# ENG-AASI18003-R1-CD-Redline-pgs.pdf Markup Summary

**FORCE MAIN
GENERAL NOTES**

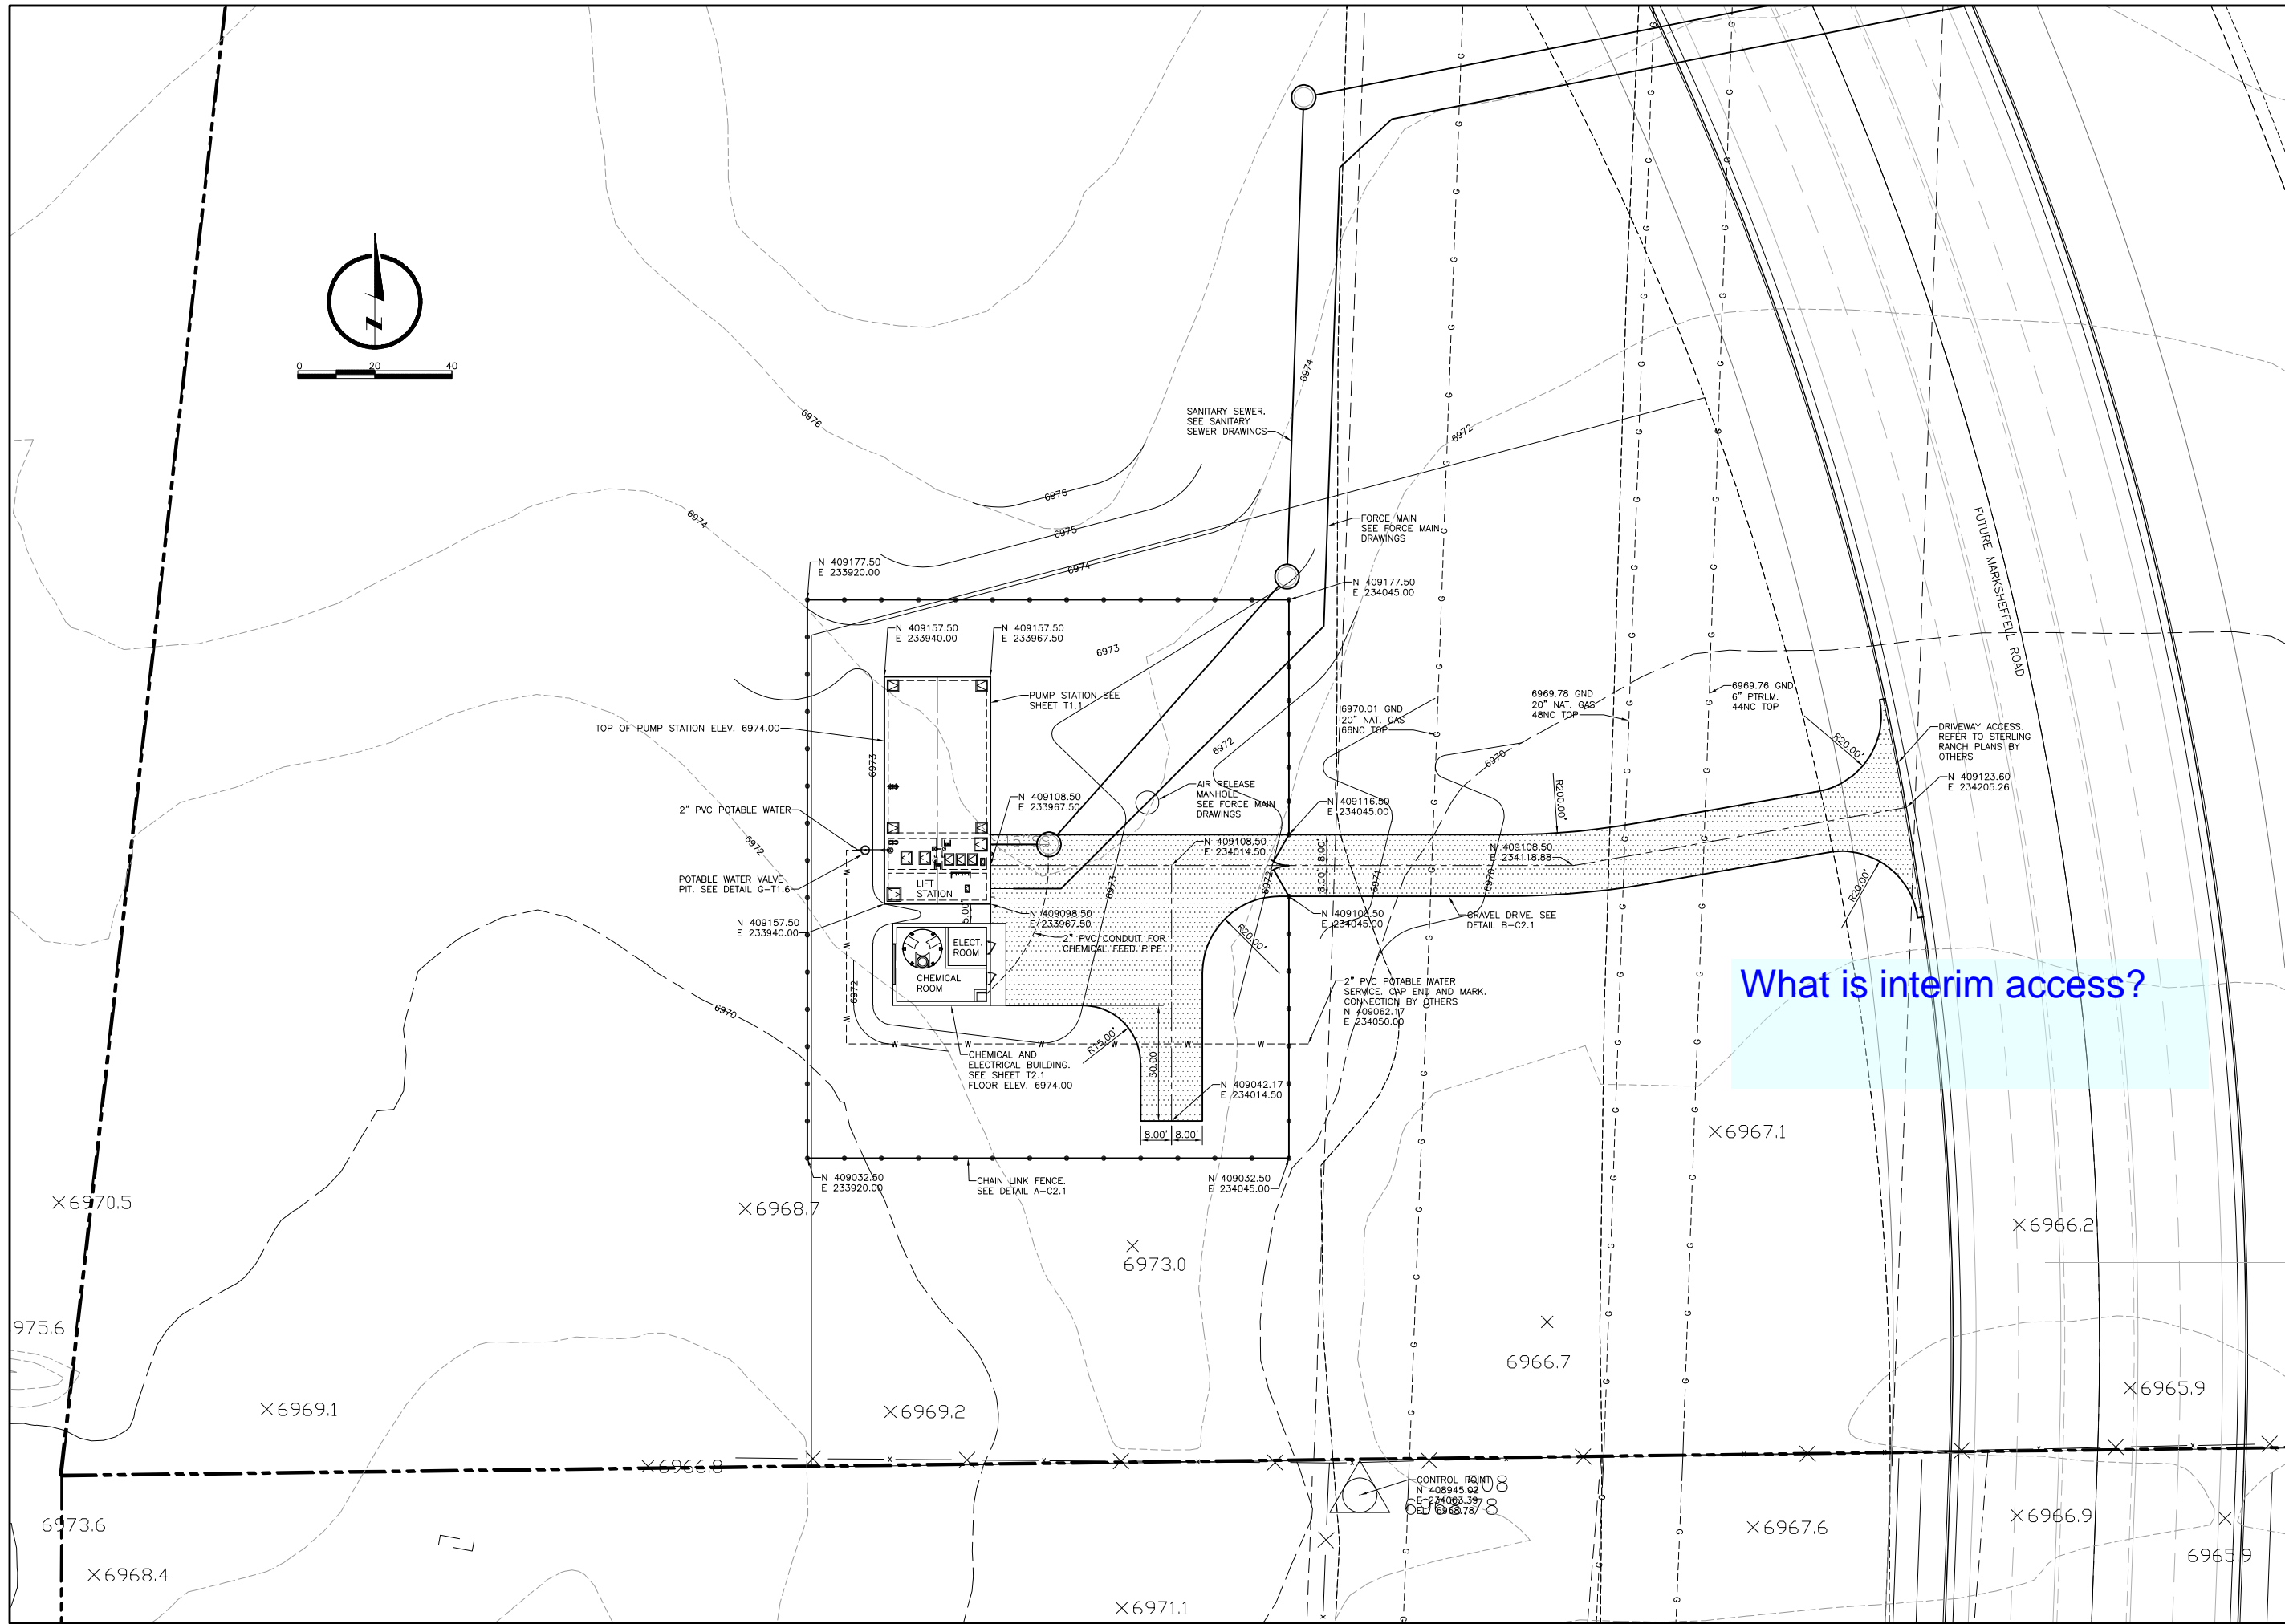
Standard notes missing?

Standard notes missing?

FM1.3

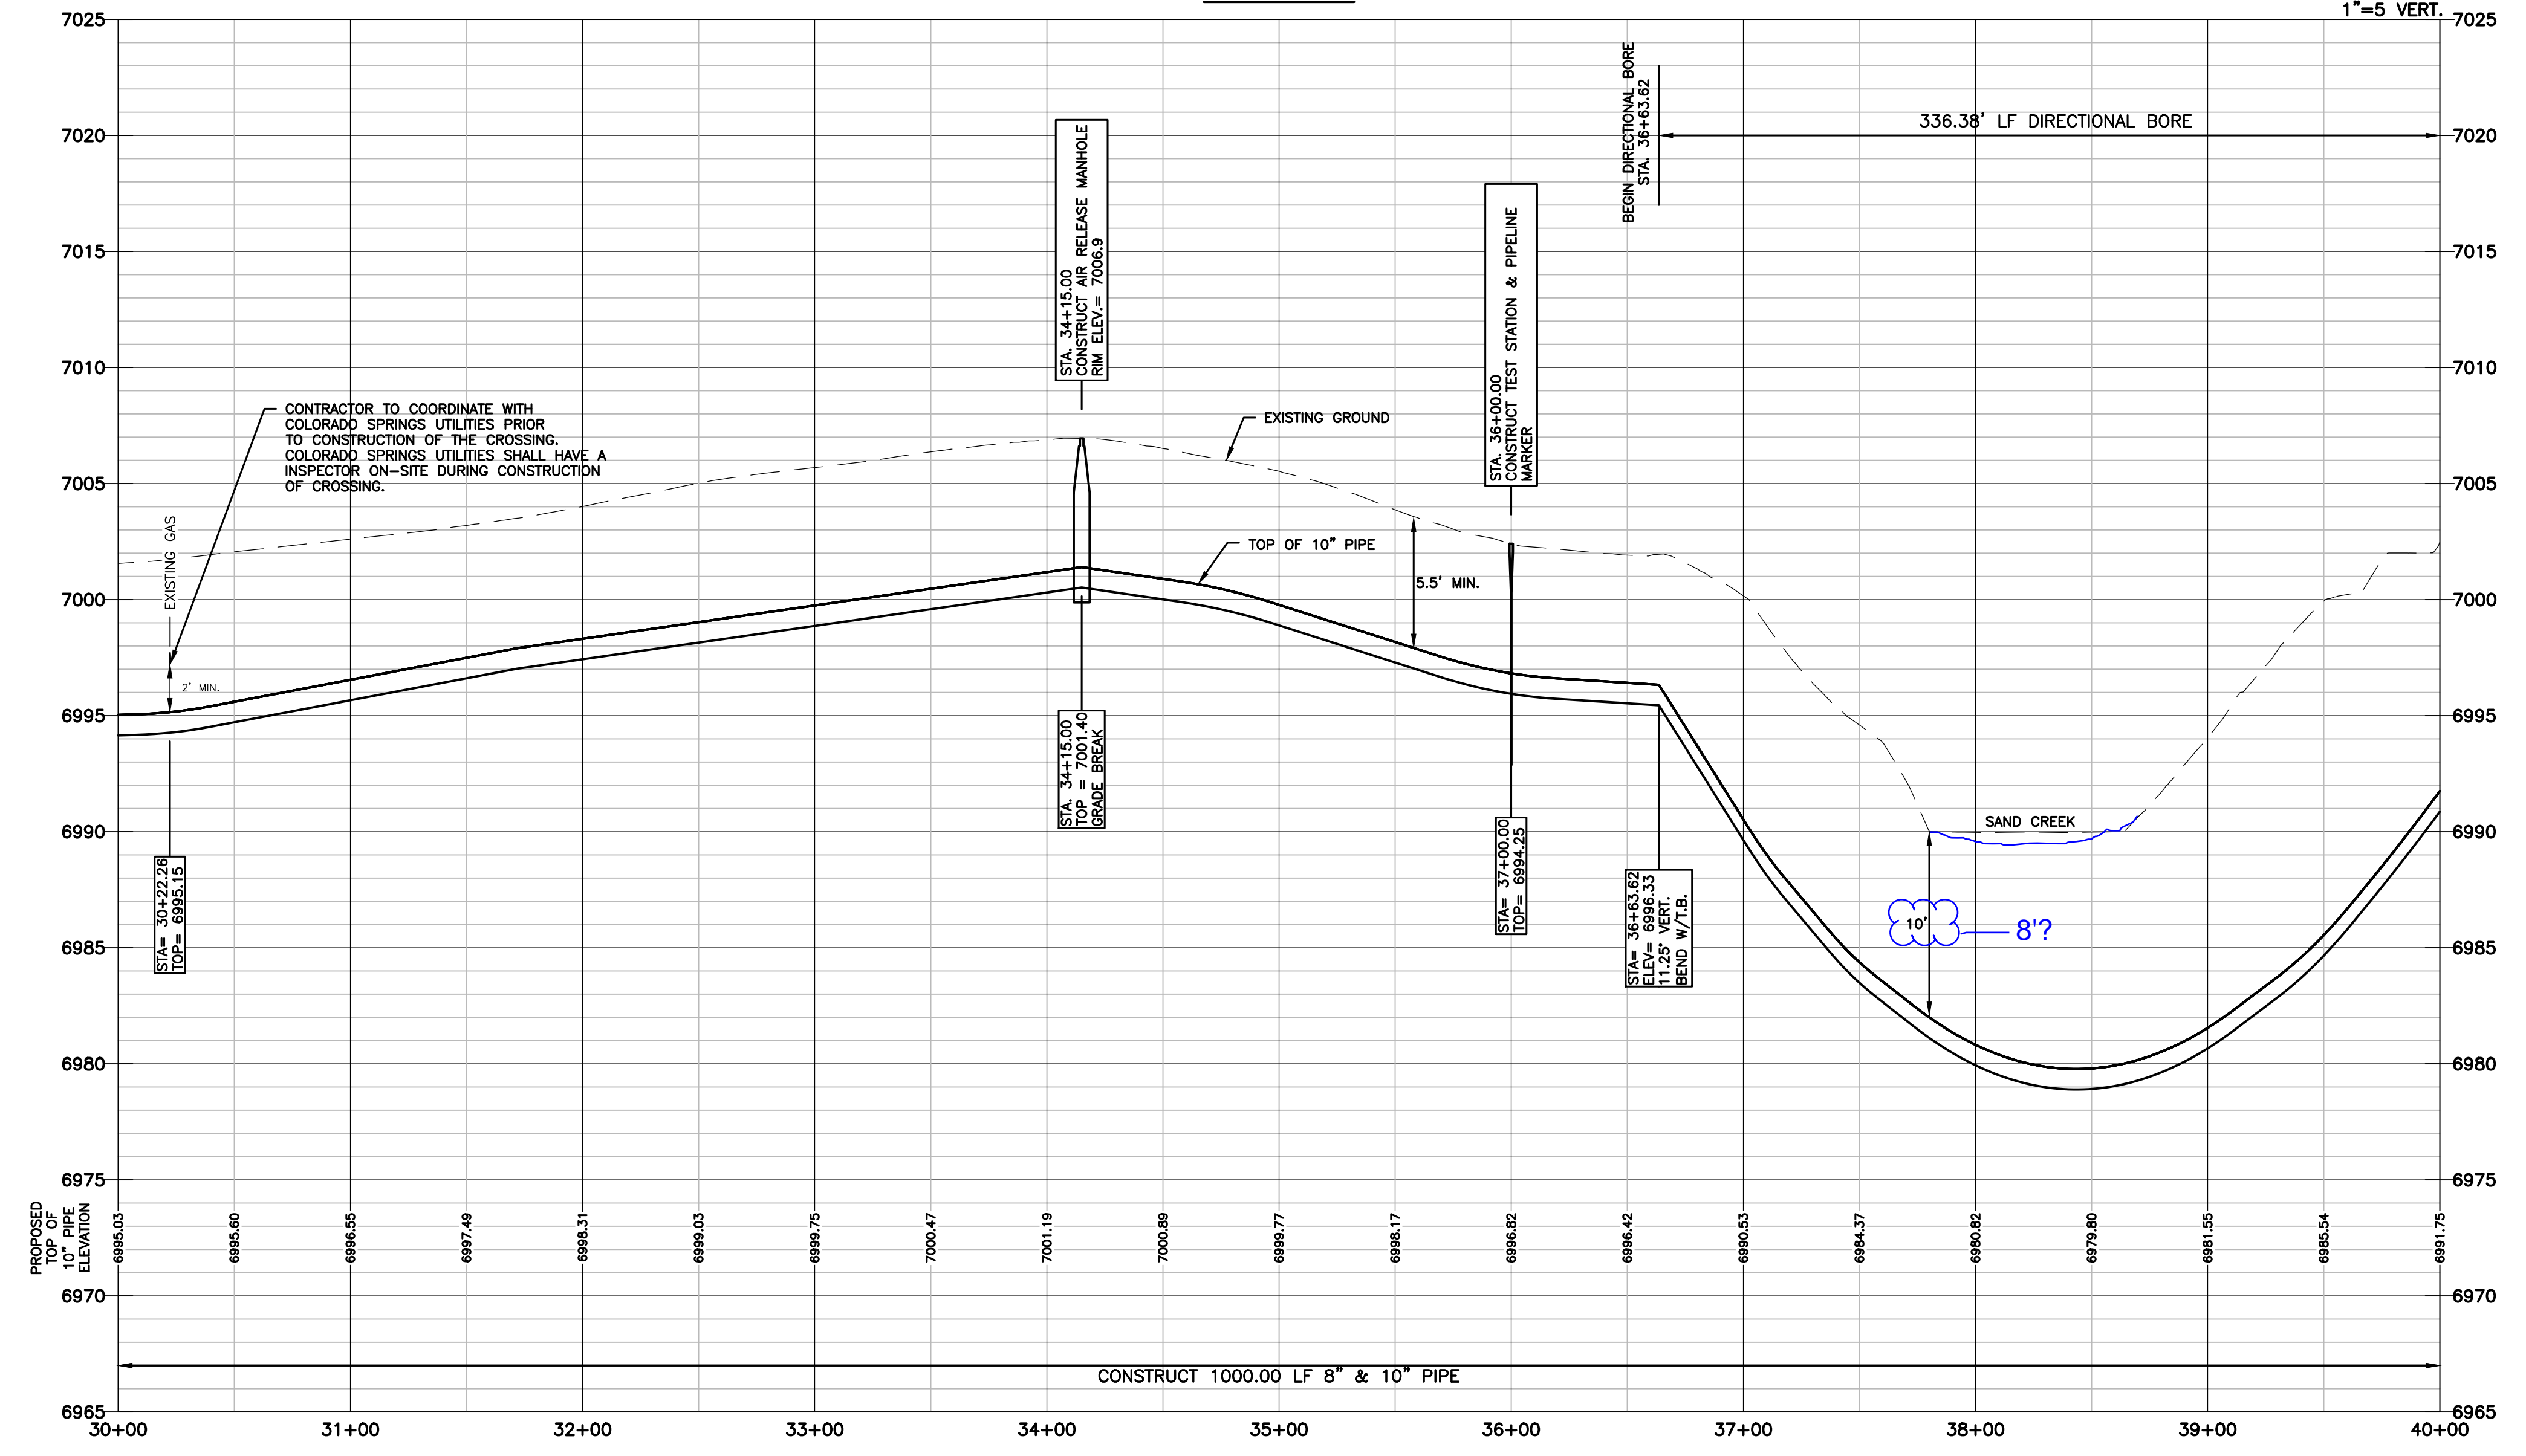
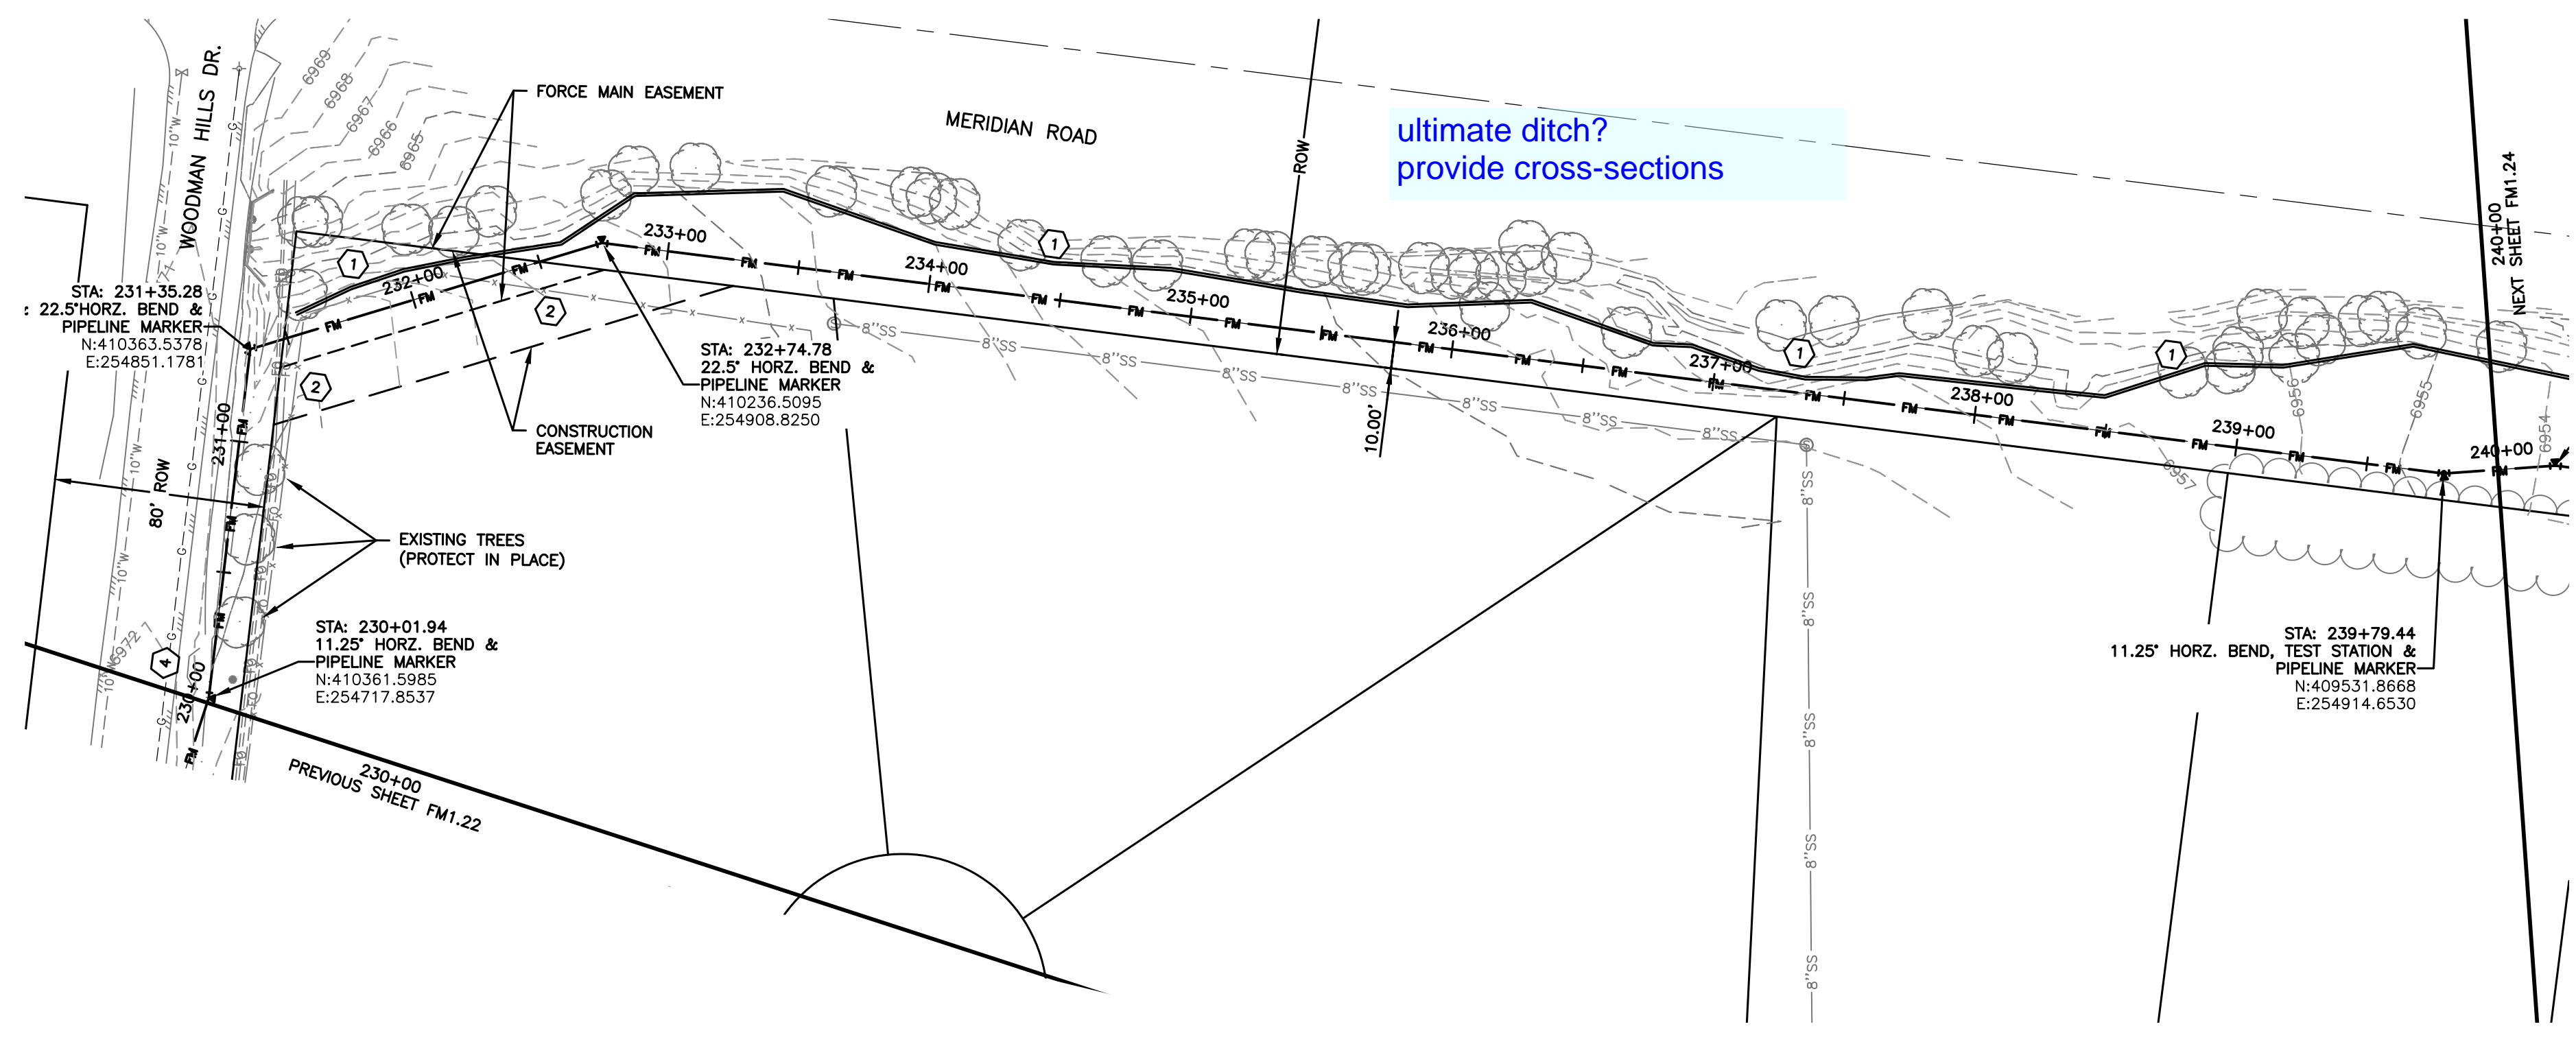
w

8'?

Channel stabilization?
